Re: The Department of Education's 'New Ultimo Public School' Development Application lodged with the Department of Planning and Environment.

Ultimo P&C Response

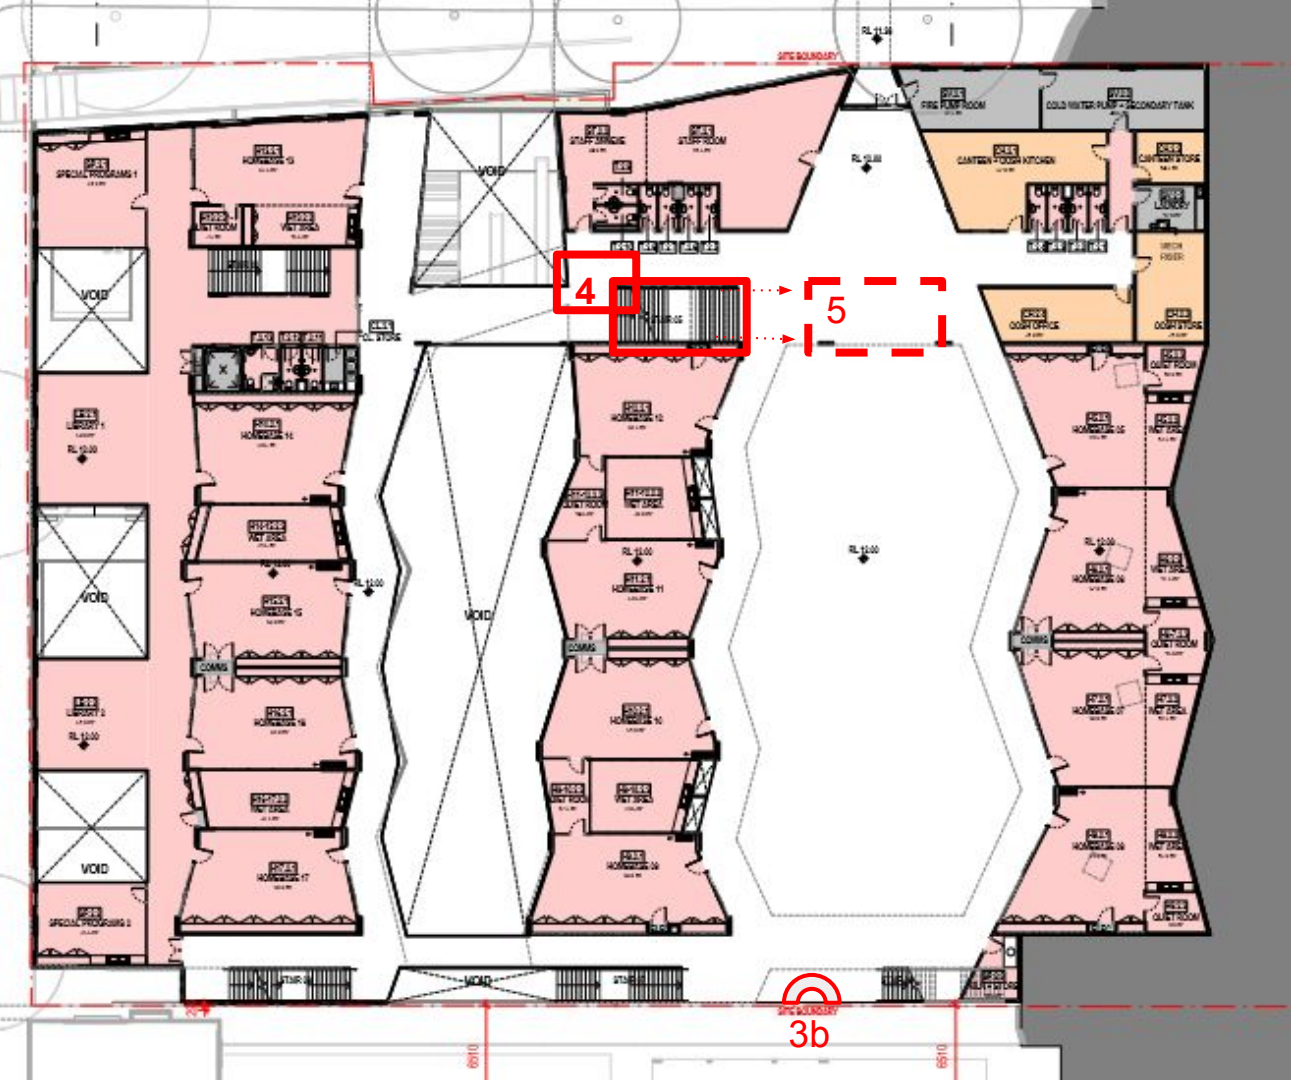
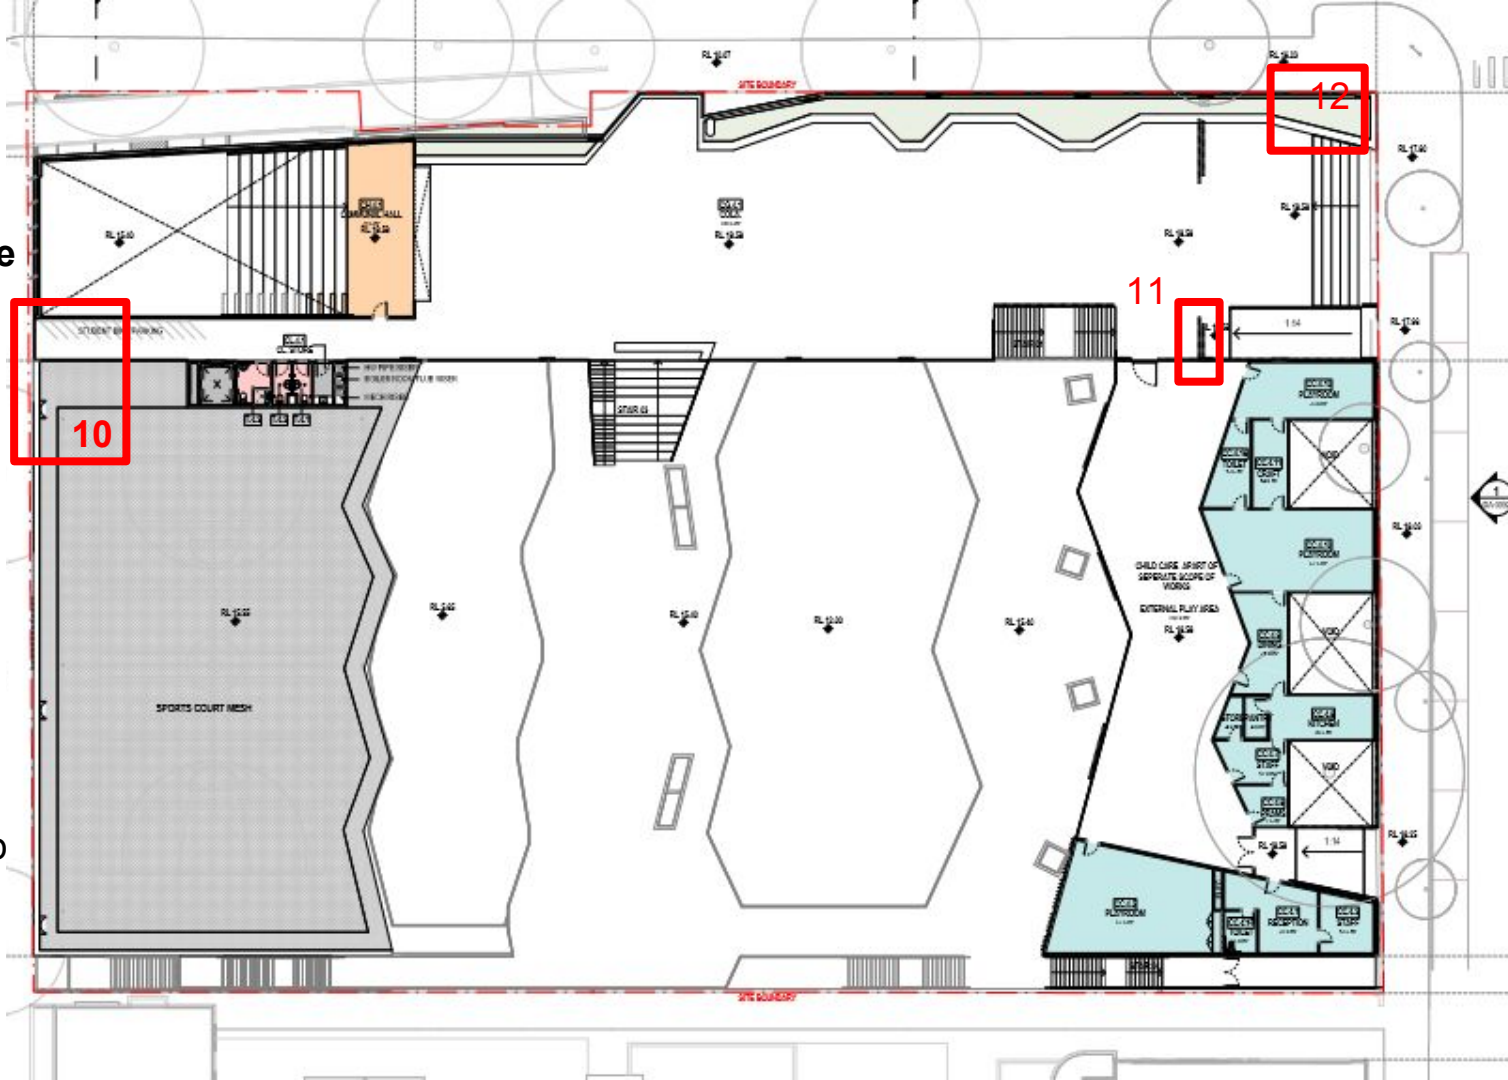
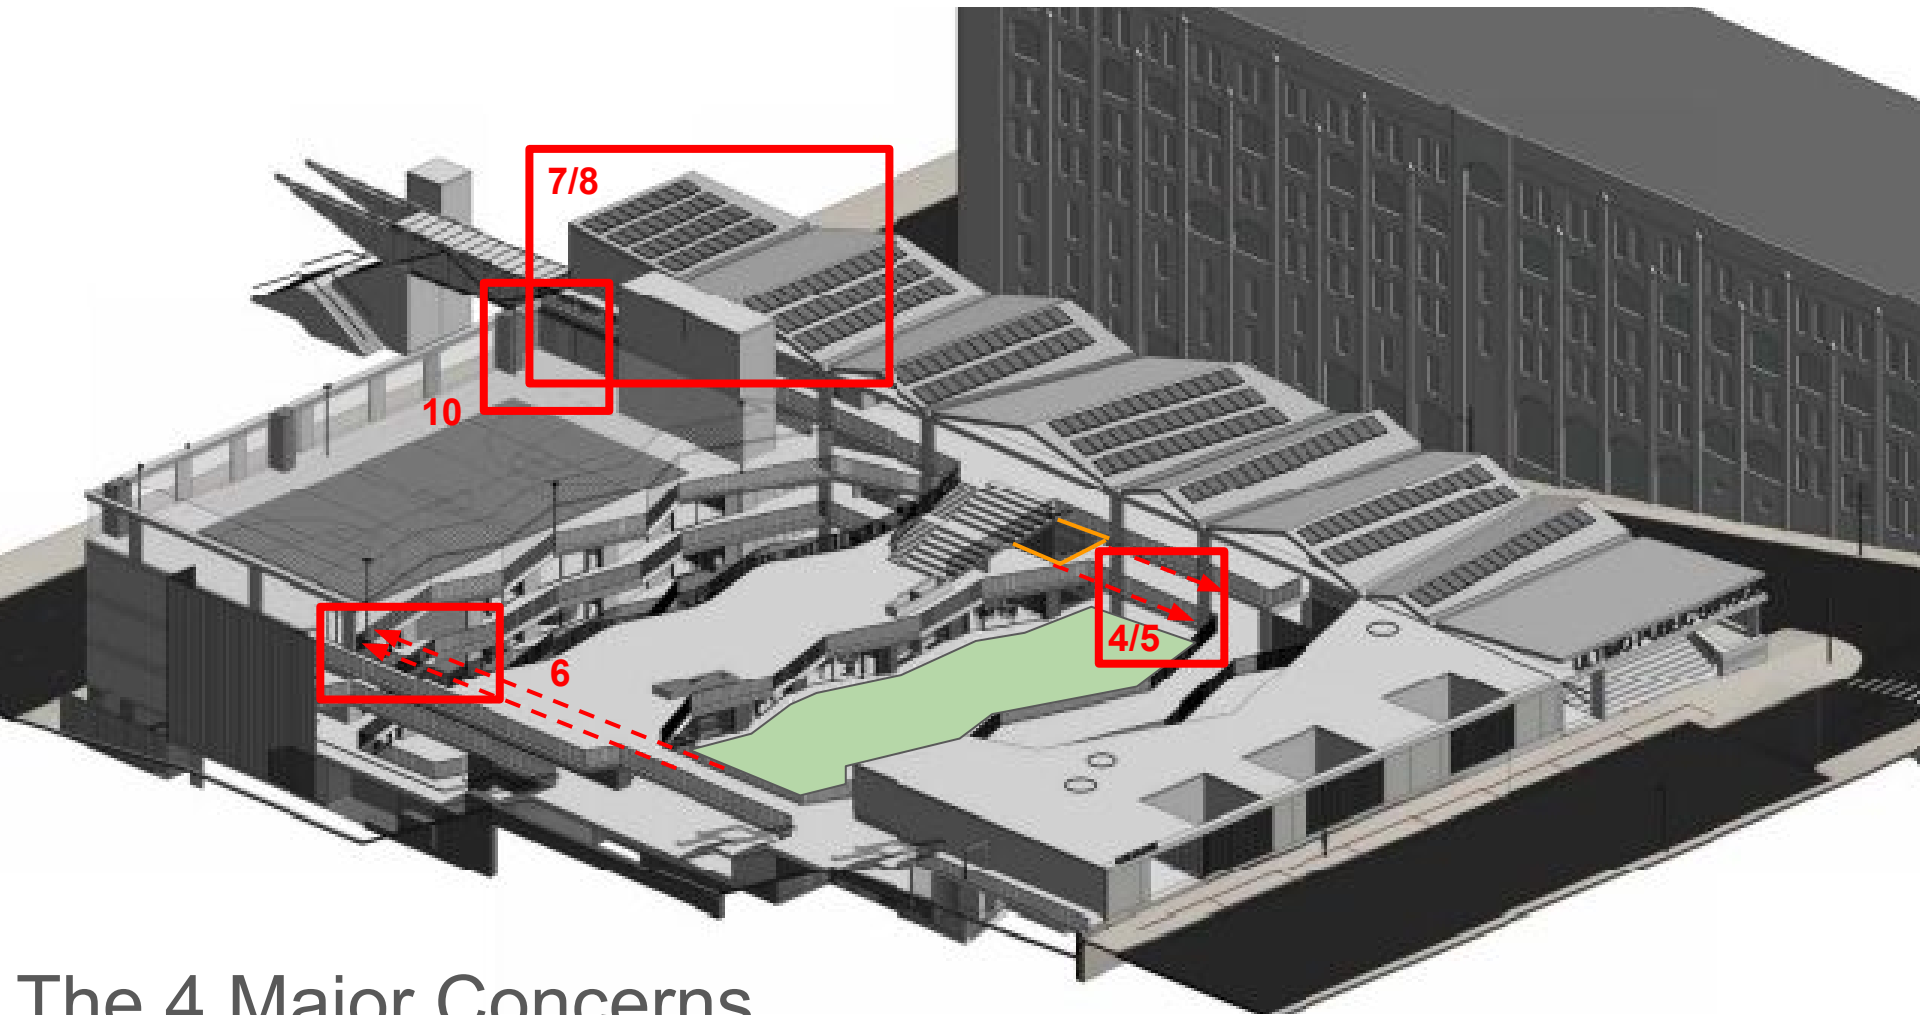
Points 7&8 - Gym and School Hall. The largest concern we have, that is not so easily solved on site is the size of the school hall in particular the gym area, it is too small. The school hall is stated to be 224 m² in size, but this should be the size of the gym area - the flat contiguous space needed for primary school kids to engage in physical and artistic activity and should not include the tiered seating area and top flat area which are nice to have but unusable for most class activities.

What makes this particularly frustrating is that directly north 'point 8' adjacent to the gym the DoE has foregone a large possible building space, we cannot understand the reasoning for this. If it is a jurisdictional block between the City of Sydney and the Department of Education that is depriving the kids of this gym space, we would ask the Department of Planning to help facilitate it's

Point 10 - COLA to Basketball Court Stair - There is no visually direct stair connection between the entrance of the school and the basketball court, this is important for 2 reasons:

Point 4&5 - Middle to Upper Playground - There is no direct visual stair connection between the deck (upper playground) and the middle playground. **Point 4** - In the current design all the students have to do a 180deg switchback on the stairs to get to the middle playground & classrooms, with around 200 students possibly doing this at one time, this is dangerous and inconvenient. **Point 5** - Moving the stairs to the head of the middle playground as indicated would allow a direct visual link all the way down to the lower playground from the COLA, and remove the bottleneck at point 4.

Point 6 - Upper playground Mid to Basketball Deck bridge - A generous direct access between these two parts of the deck are required to move the students directly, safely and comfortably between the deck spaces. This is particularly important for evacuating the Basketball Court cage, and allowing room for a tree and wet weather circulation.
